Re: PA23-018 – Pilchuck Rentals CUP – Technical Review 1  
Job. No.: 21c-4287

To: Amy Hess  
City of Marysville – Community Development Department  
501 Delta Avenue  
Marysville, WA 98270

### **Technical Review 1**

LAND USE SET
PRELIMINARY SEWER-WATER PLAN

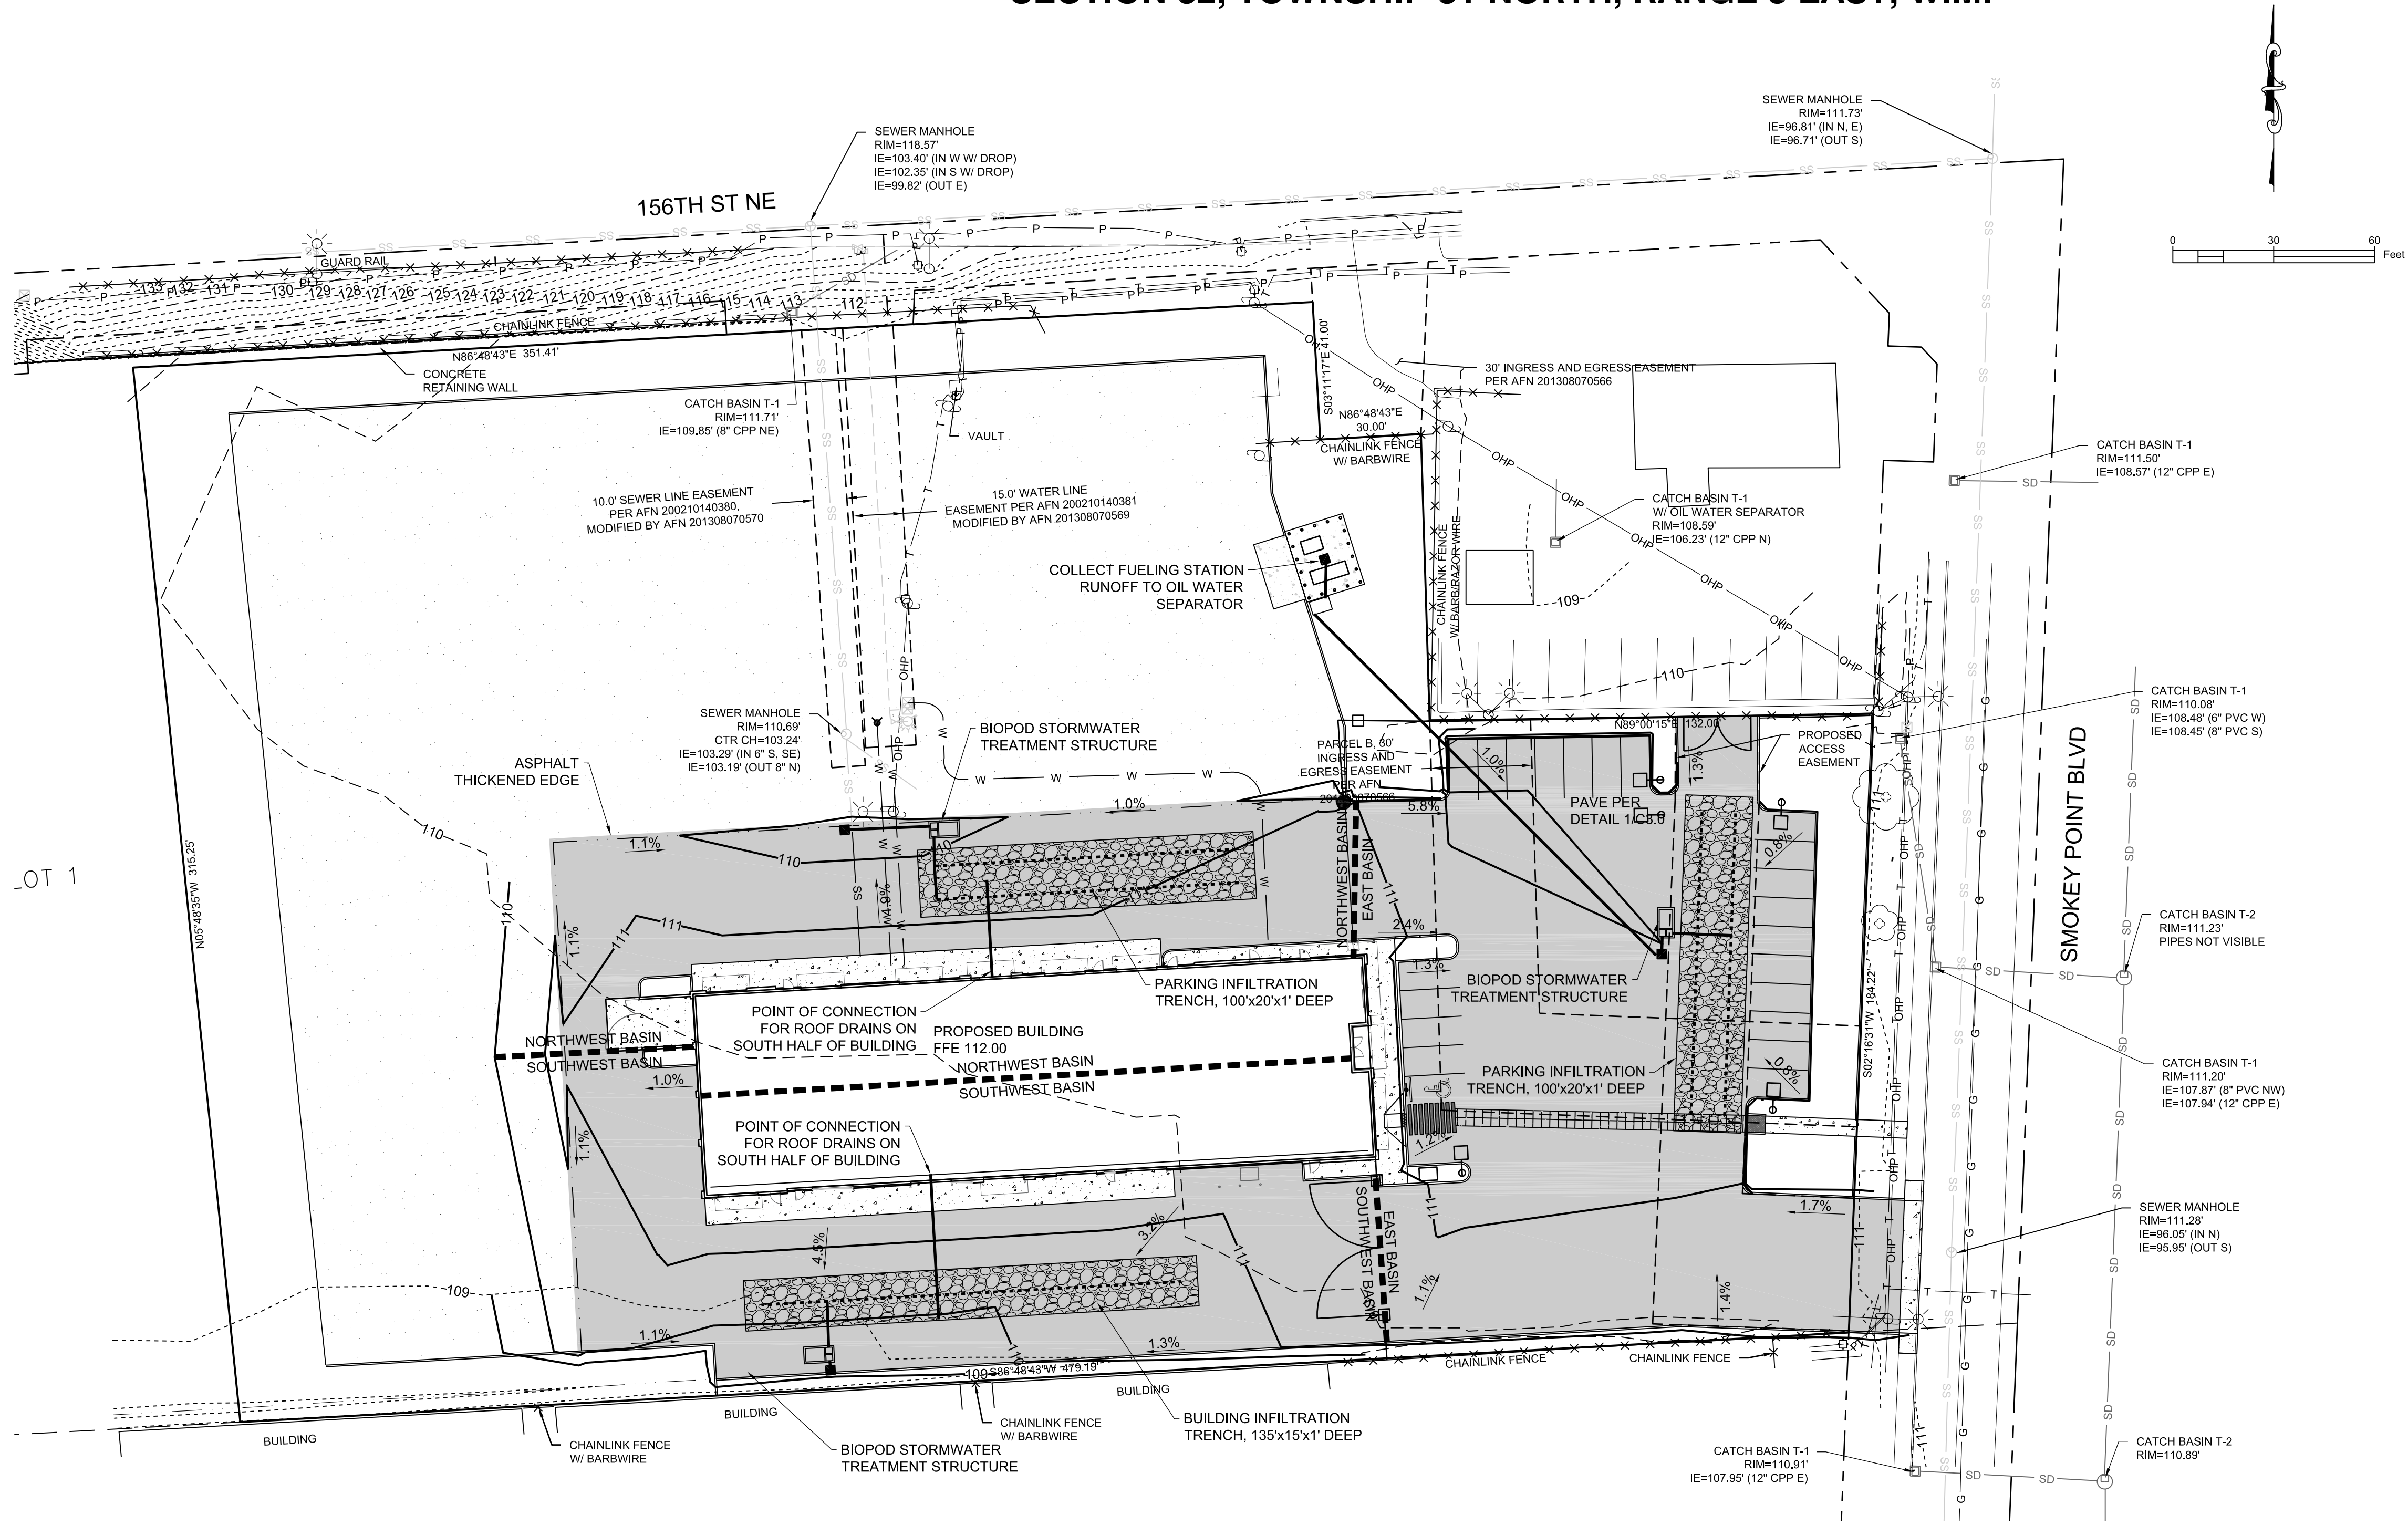
10. Plans for underground fire sprinkler piping shall be shown on civil construction water plans, and submitted for fire marshal review and approval.

*Refer to C2 for underground fire sprinkler piping.*
